Ref : S6/2014/0227/FP - Erection of single storey rear and side extension and first floor side and rear extension at 17 Kingsmead, Cuffley

I have received details of the above planning application. I object strongly to the above mentioned extensions for the following reasons.

Dwg. No. PA.04A

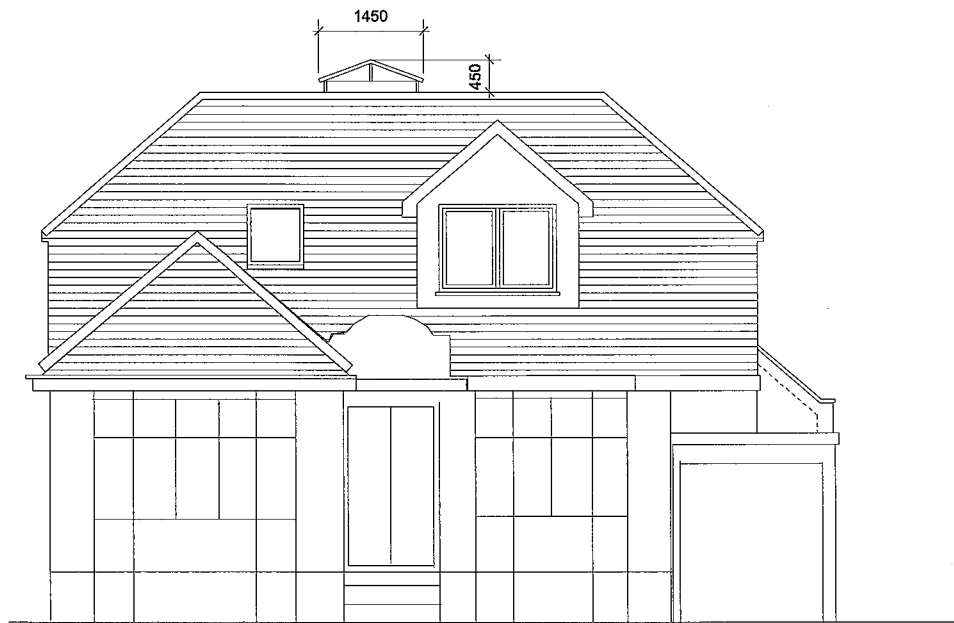
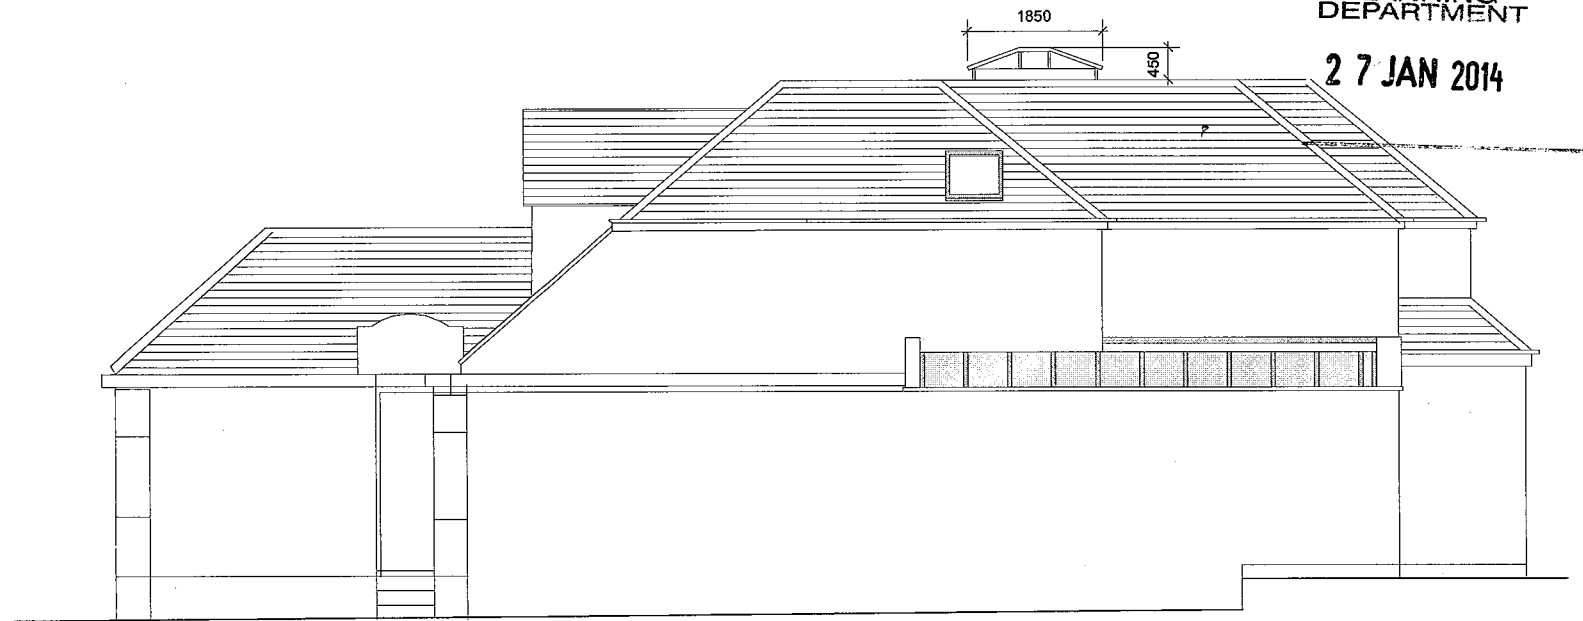
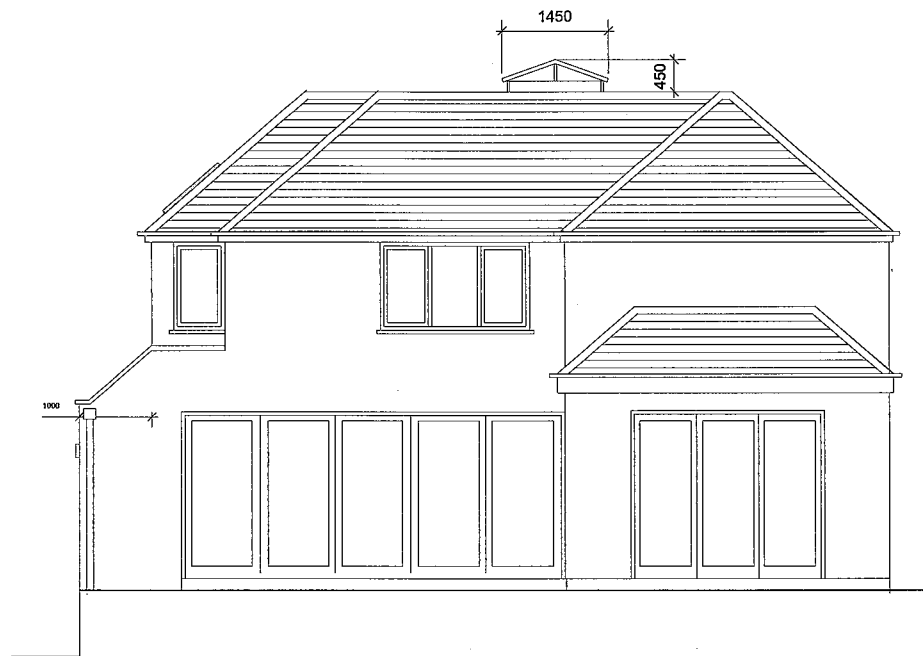
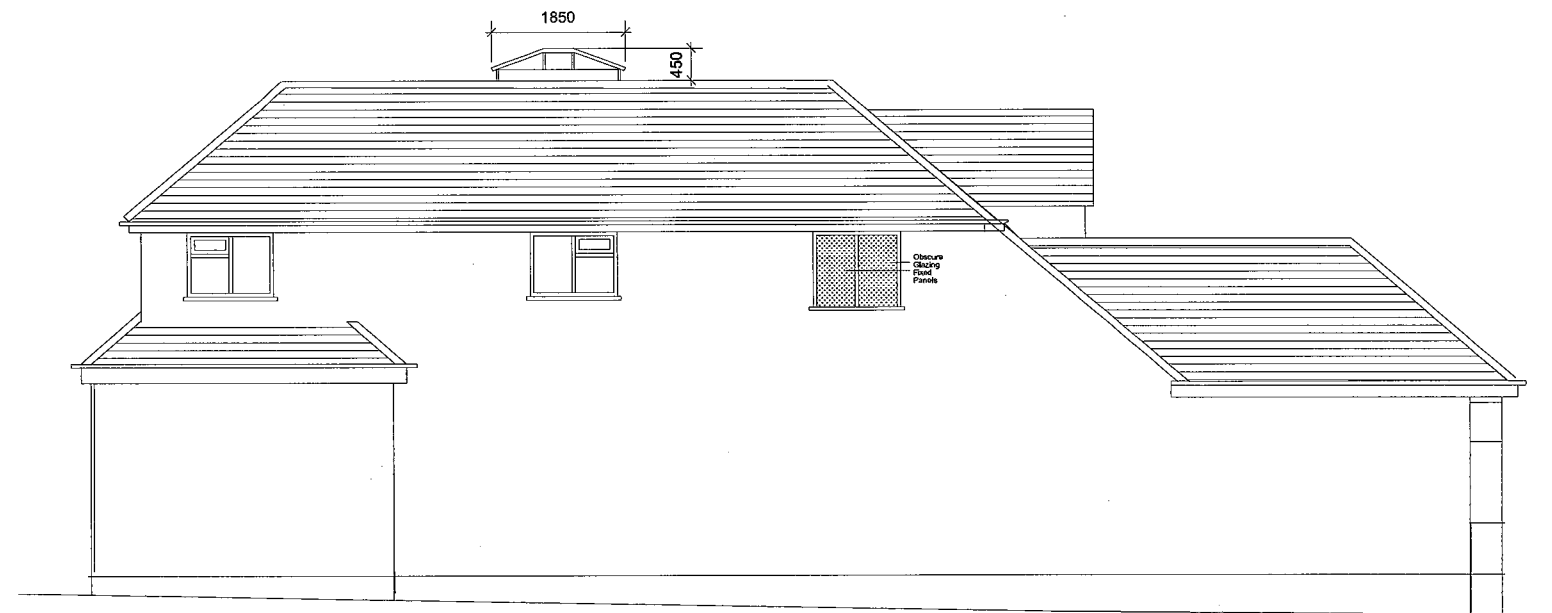
1. Kingsmead is a road in which all the existing properties are bungalows. The alteration of number 17 into a two storey residence would alter the whole aspect and atmosphere of the road.

2. Previous residents of number 17 had already constructed a single storey rear extension that completely blocked the view I had of the countryside at the bottom of my garden and thus took away the lovely view that existed from my property looking towards the bottom of my garden. The addition of a storey onto the entire property would totally destroy any view at all apart from the side of the building itself.

3. If the application to build an additional storey on the whole property is approved it would dramatically reduce the amount of light that would be able to reach that part of my garden. Since that part of my garden is used as my vegetable and fruit tree patch there is no doubt that the extension would have a very adverse effect on its productivity.

4. In addition the effect on the growing potential of that part of my garden I see from the plans that the planning application also shows that it is intended to install three windows in the wall that overlooks my garden. This would totally destroy my privacy and take away any possibility of my spending any secluded time there as I would always feel that I am being overlooked/watched.
